**Re: Falcon Marketplace Final Plat (SF-19-001 CDR-16-007)**

Please accept this response letter to comments received February 28, 2020

SURVEY CONTROL

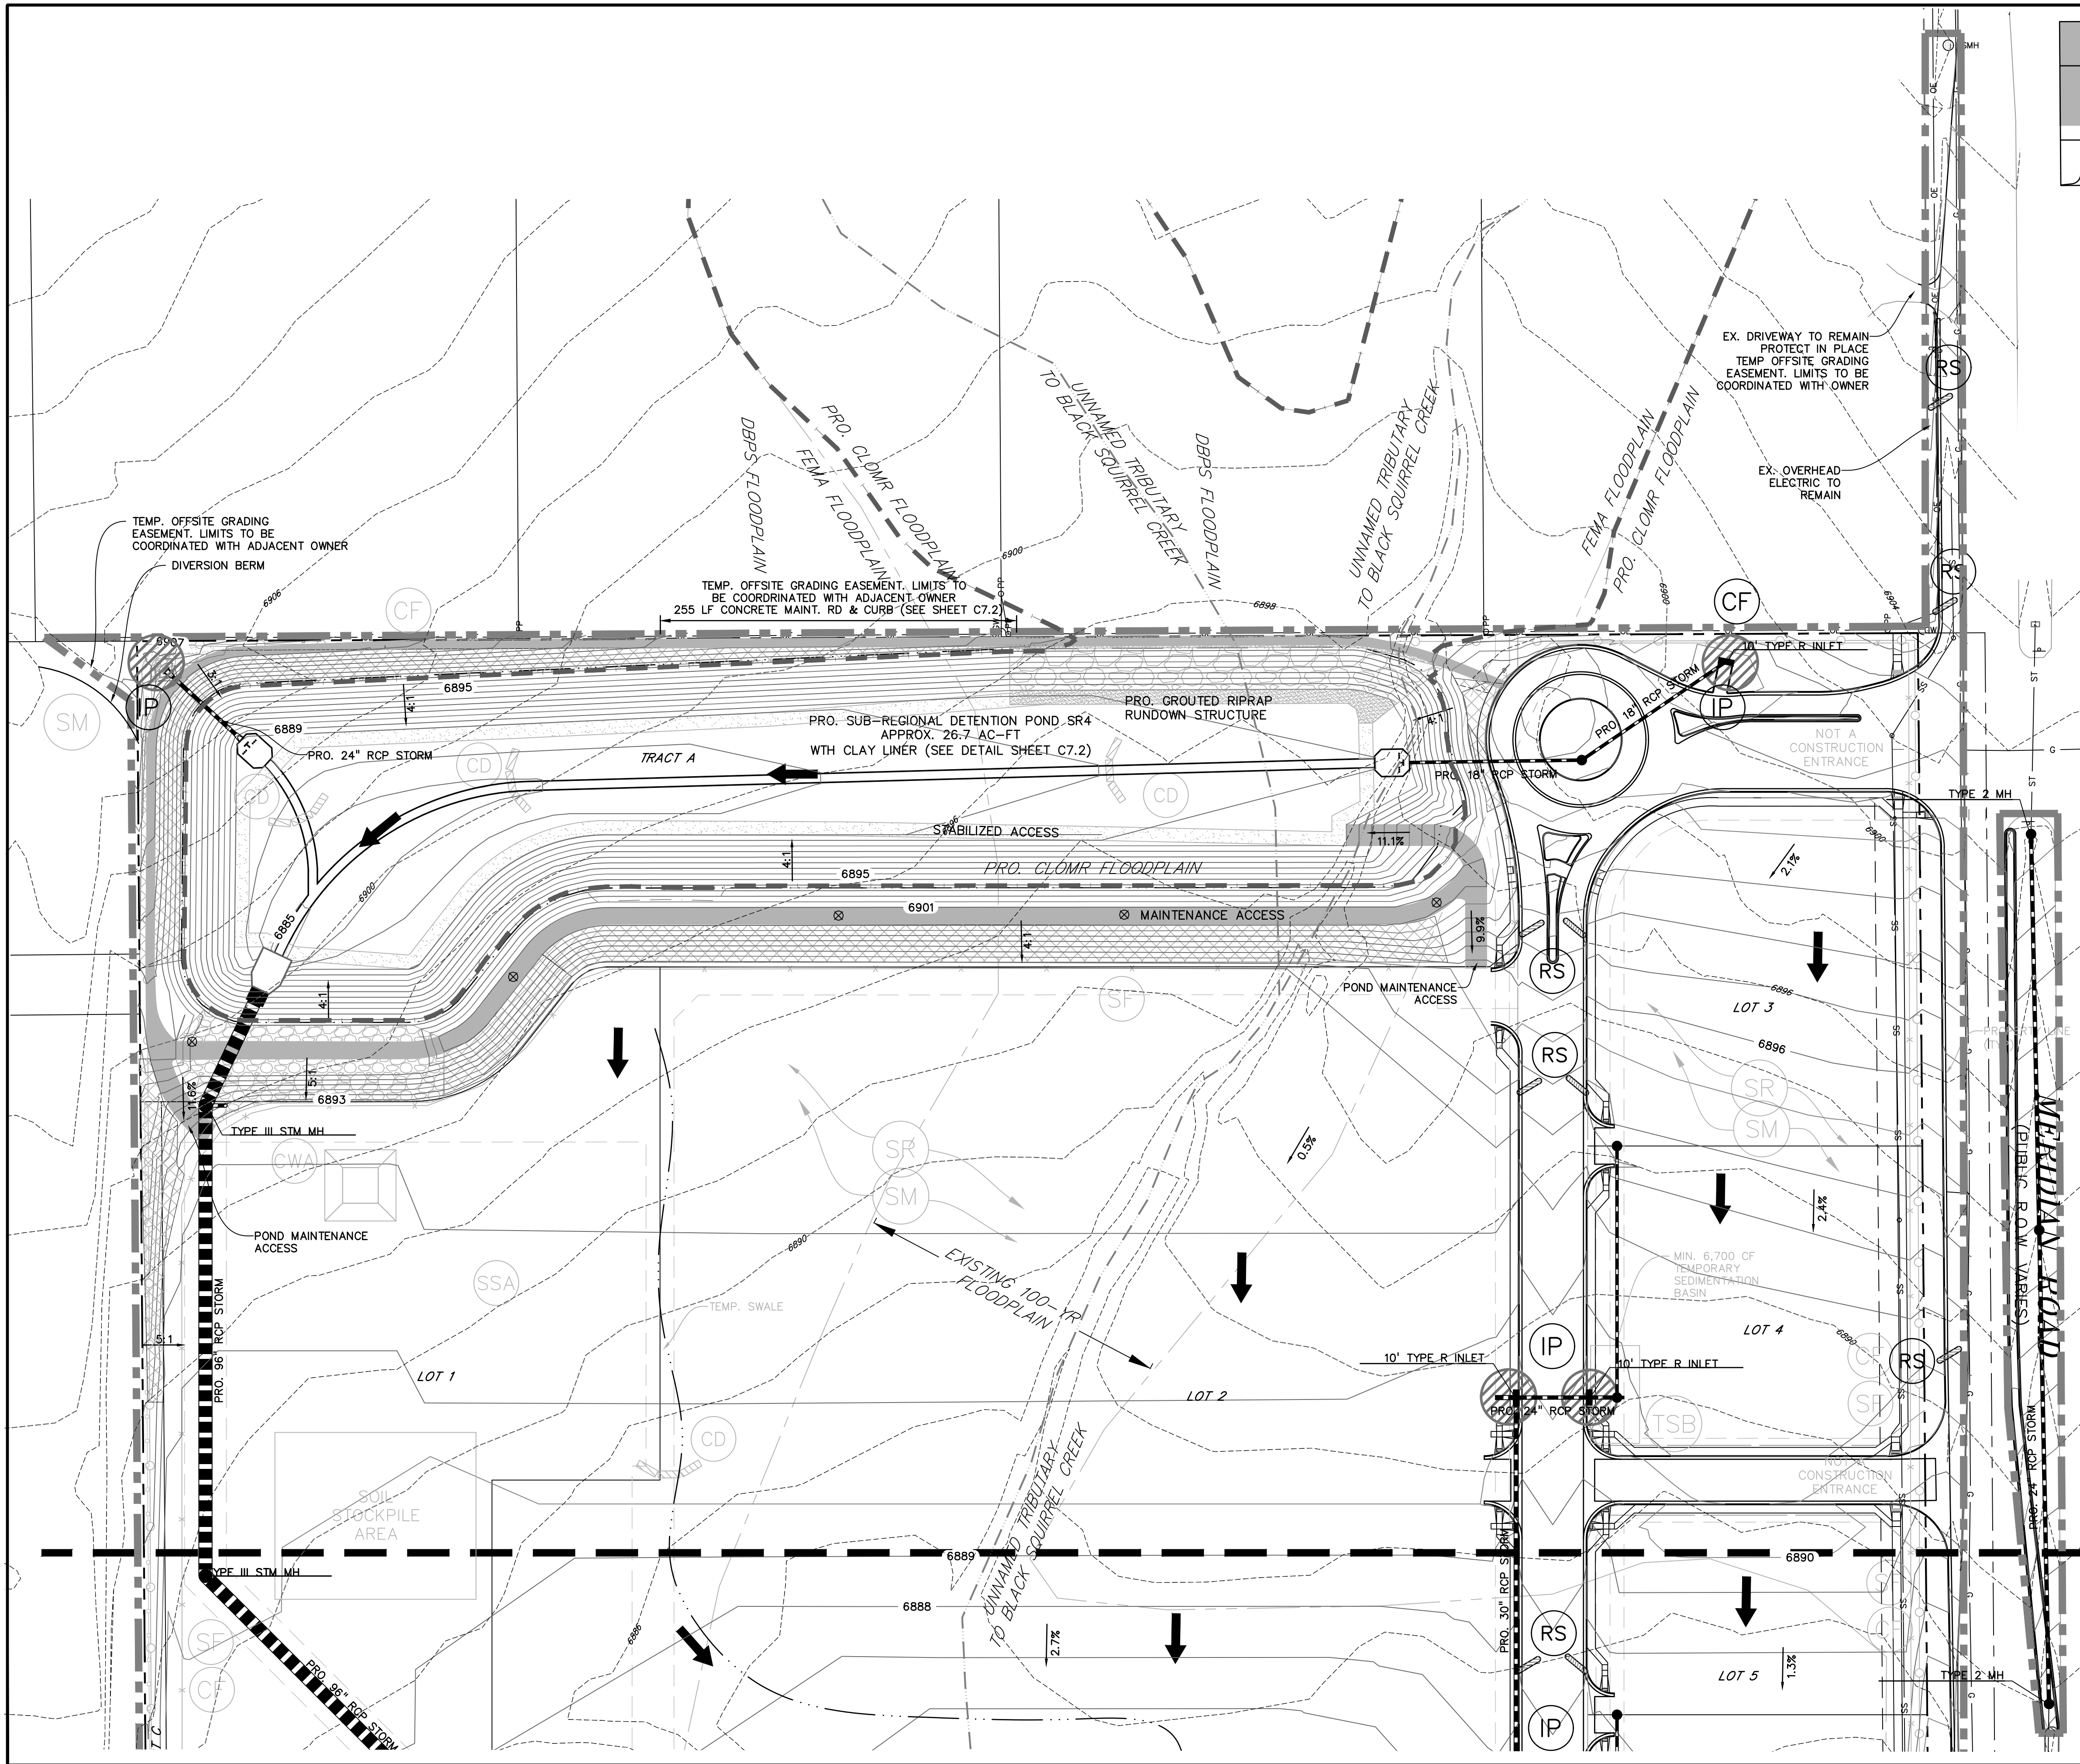
- b. Address anticipated pond SR4 embankment settlement. Provide additional study and construction requirements when available. Resolved; tracking of settlement will be addressed at construction stage. **Provide monitoring plan details. Partially resolved; provide complete details when available. Monitoring plan details added to survey control sheet.**

MERIDIAN ROAD
TURN LANE
EXTENSION

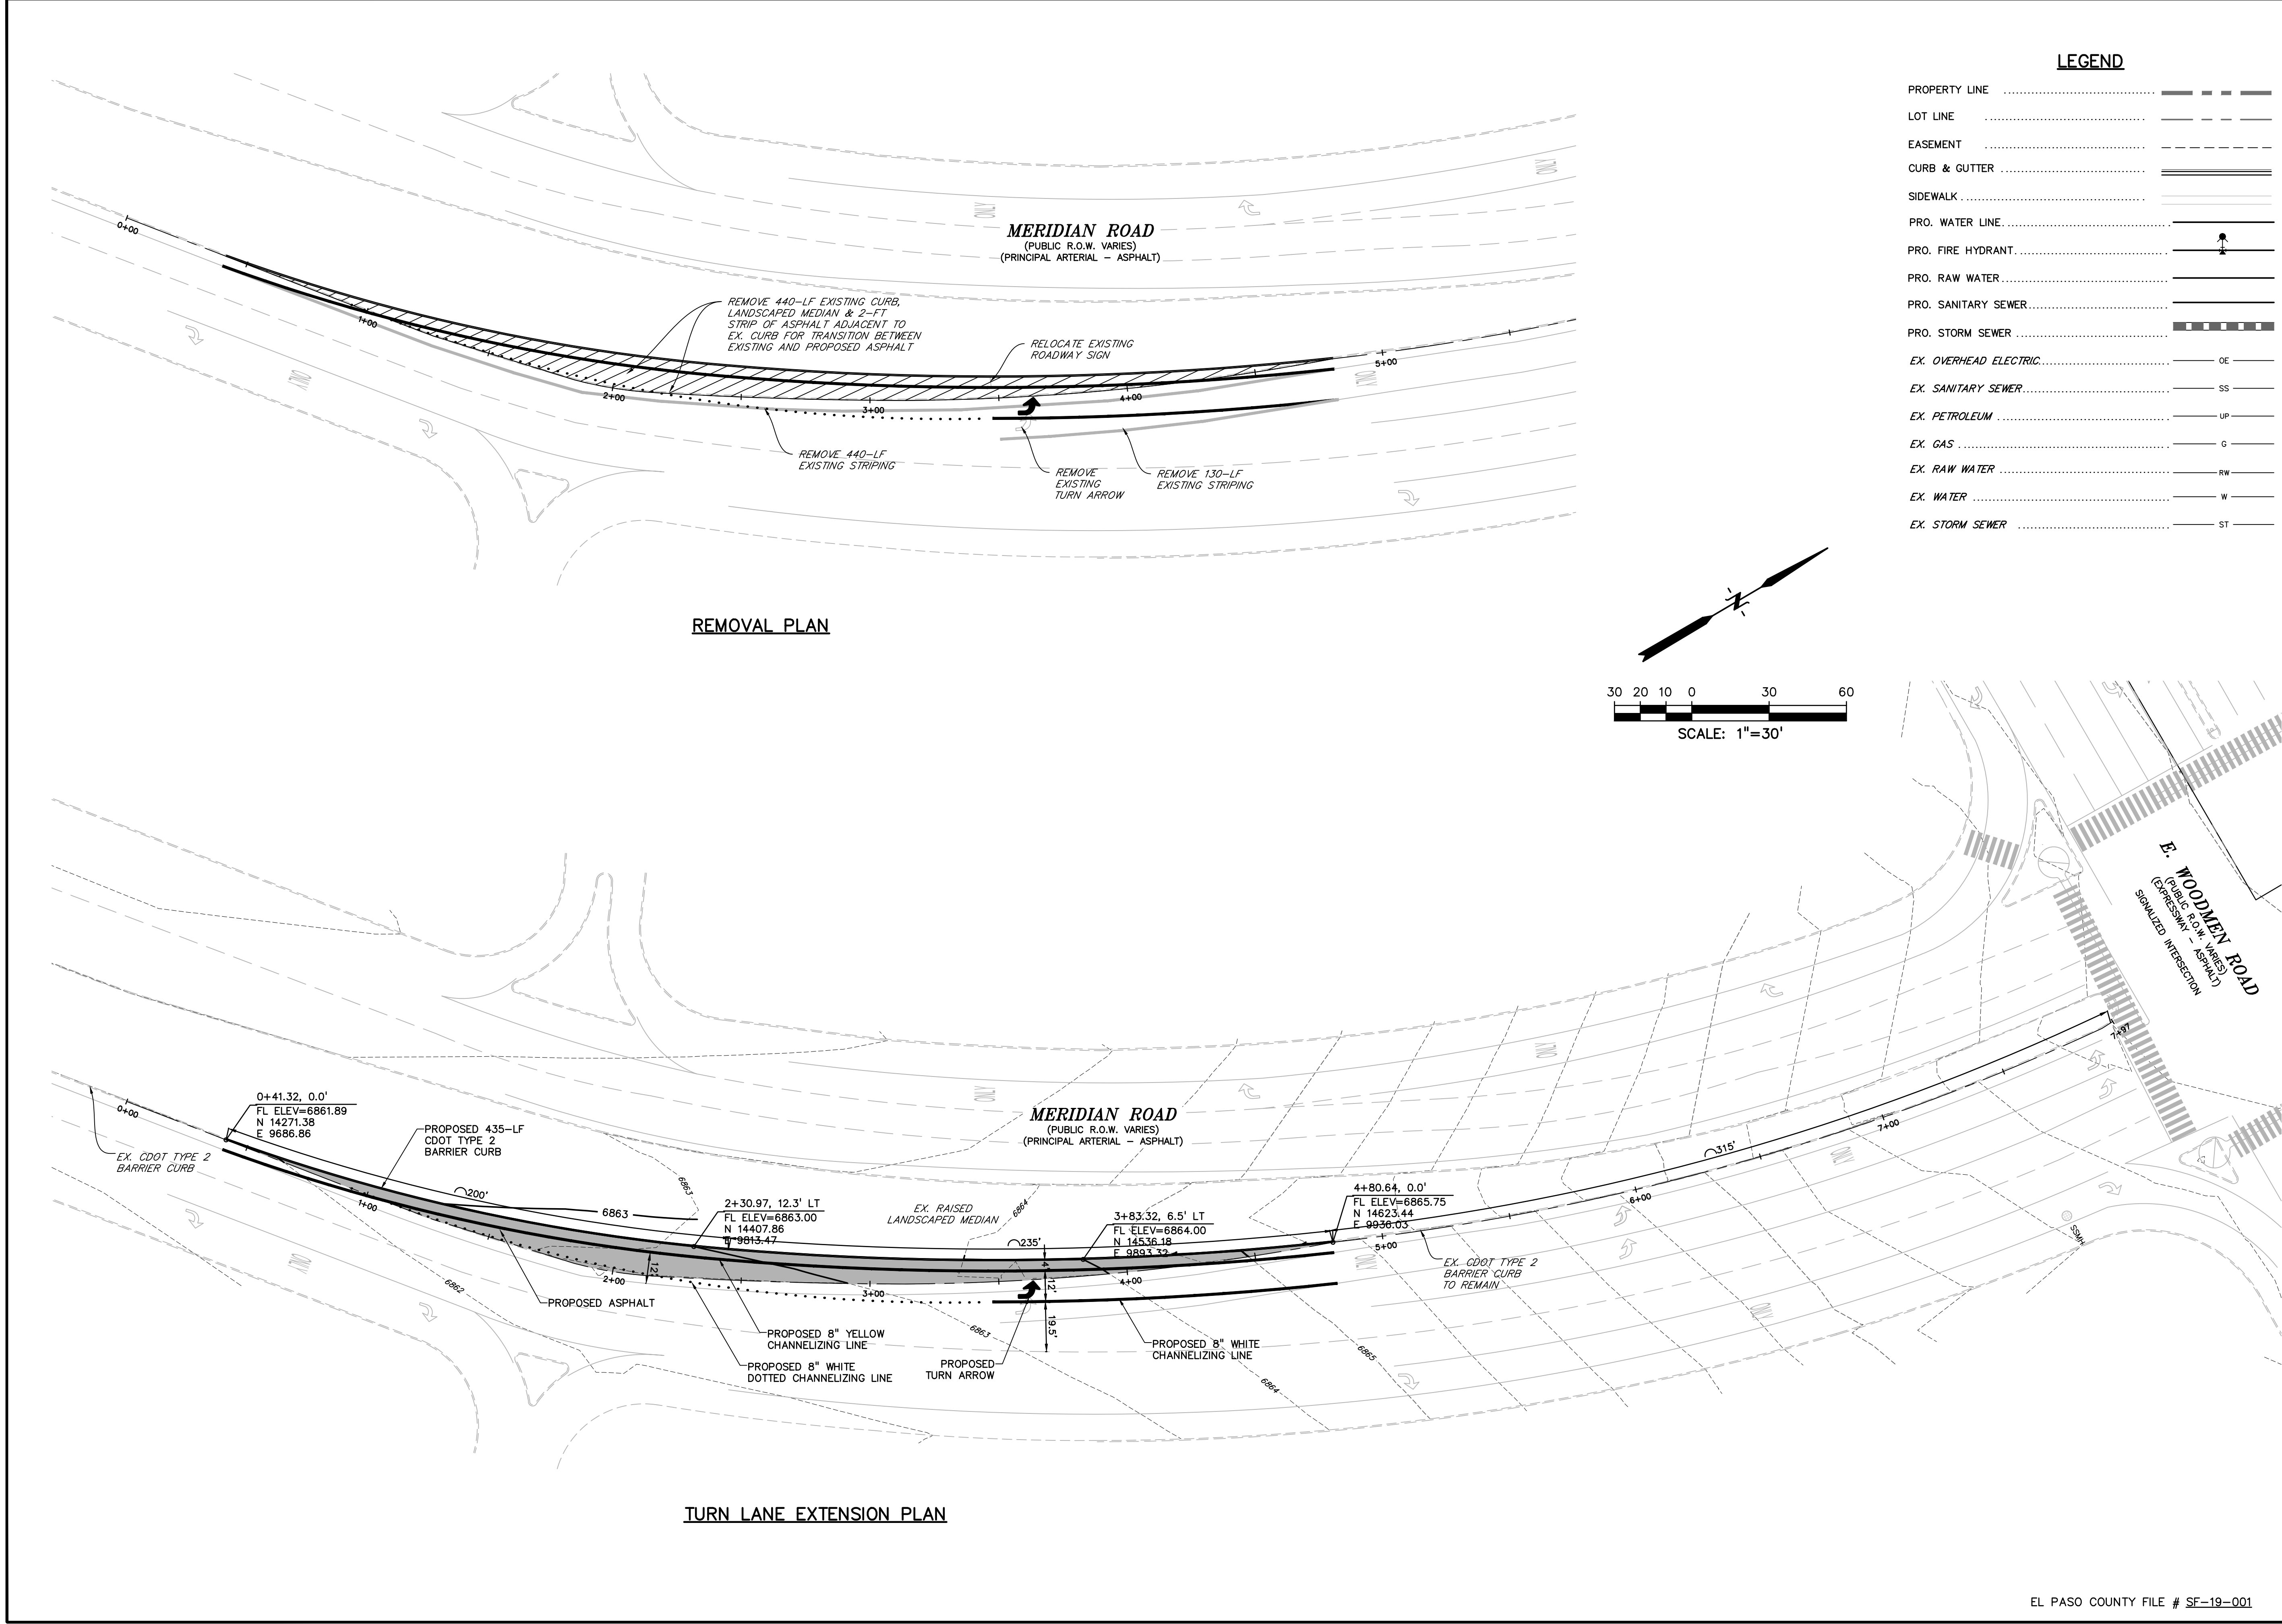
13. Resolved.
14. On Sheet C4.10 show all drainage/utility facilities next to the lane extension. Verify that guardrail is not required. **Unresolved.** *Show all information on the plan and address guardrail warrants, clear zone and vehicle speeds in the response. Is the check dam and north side of the ponding/channel area outside of the area of concern? See updated/remaining redlines; verify that additional guardrail is not required due to non-recoverable slopes and the proposed headwall. Partially resolved; see redlines on the new sheets. Update guardrail specifications. Guardrail specifications updated to the 2019 edition.*
